DRB CASE ACTION LOG (PREL & FINAL)

DRB Application No.: 06DRB-00264 (P&F) Project # 1004721
Project Name: OAKLAND HEIGHTS & OAKLAND NORTH
Agent: Terrametrics of New Mexico Phone No.: 345-4254

**PROJECT # 1004721          APPLICATION # 06DRB-00264**

**RE: Lot 6-P1, Oakland Heights and Tract A, Oakland  
North/minor plat**

**PLAT OF**  
**LOT 6-A-P1**  
**OAKLAND HEIGHTS SUBDIVISION**  
**AND**  
**TRACT A-1**  
**NORTH OAKLAND SUBDIVISION**  
 SITUATE WITHIN  
**PROJECTED SECTION 17**  
**T.11N., R.4E., N.M.P.M.**  
**ELENA GALLEGOS LAND GRANT**  
**CITY OF ALBUQUERQUE**  
**BERNALILLO COUNTY, NEW MEXICO**

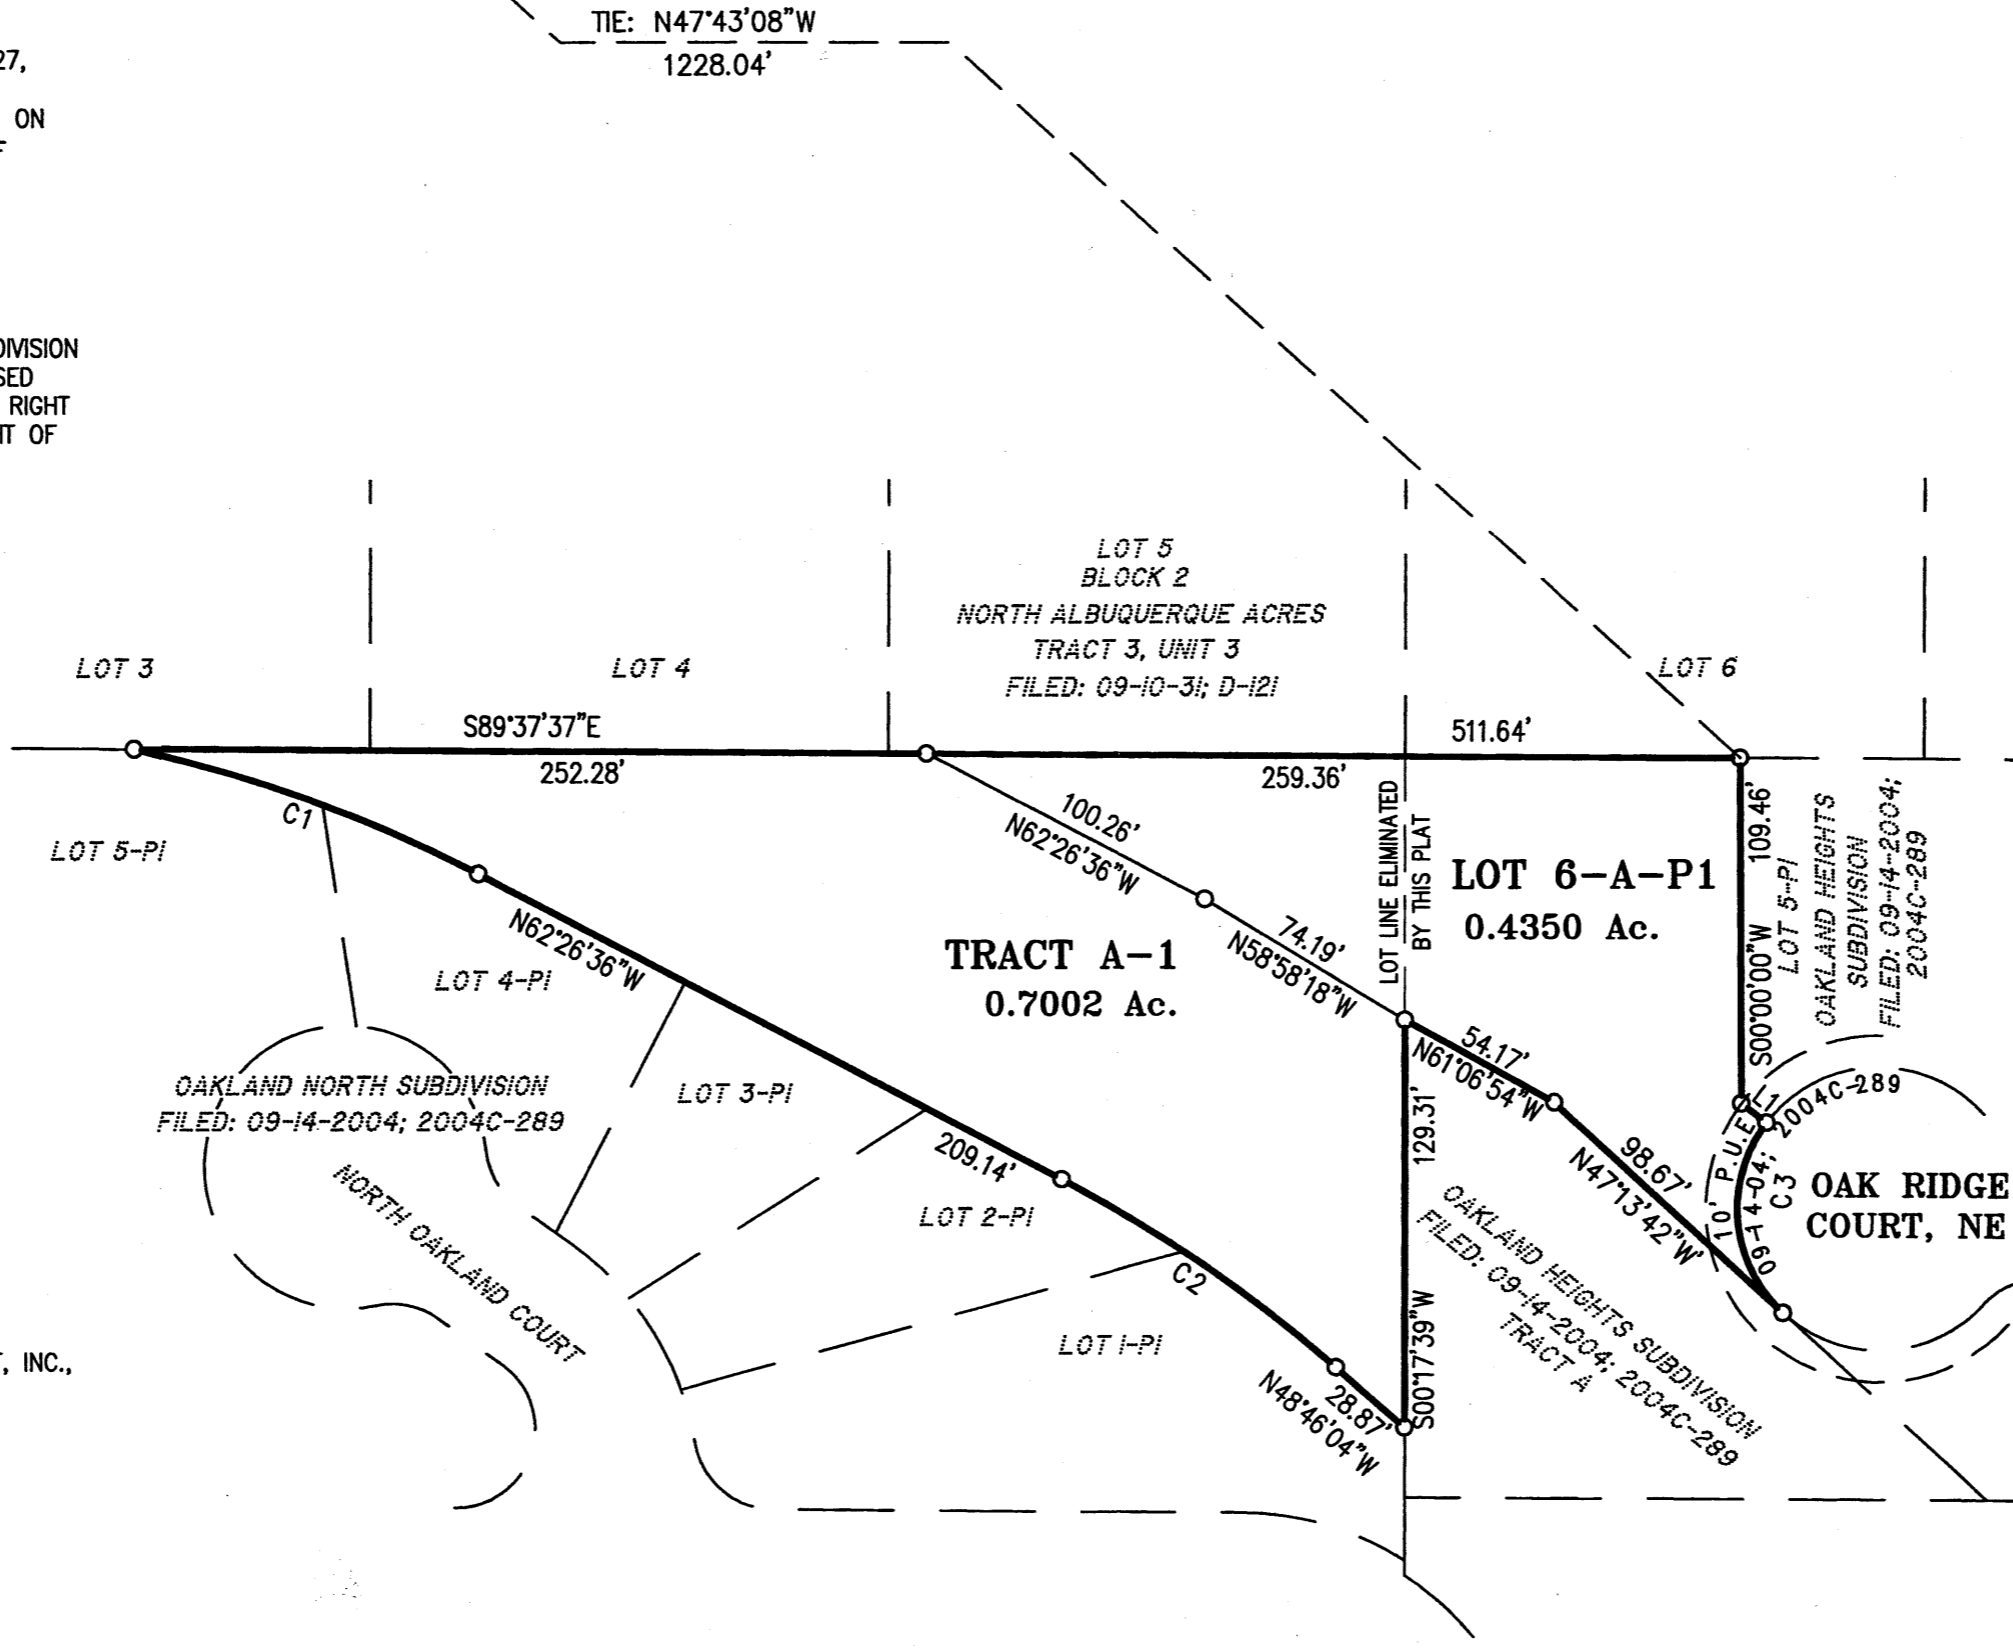
The current zoning is missing on the plat.

Tract A, Oakland North was entirely encumbered by a COA drainage easement. This easement must be identified on lot 6A and Tract A-1.

Tract A-1 should be dedicated to AMAFCA by this platting action. They will sign for AMAFCA.
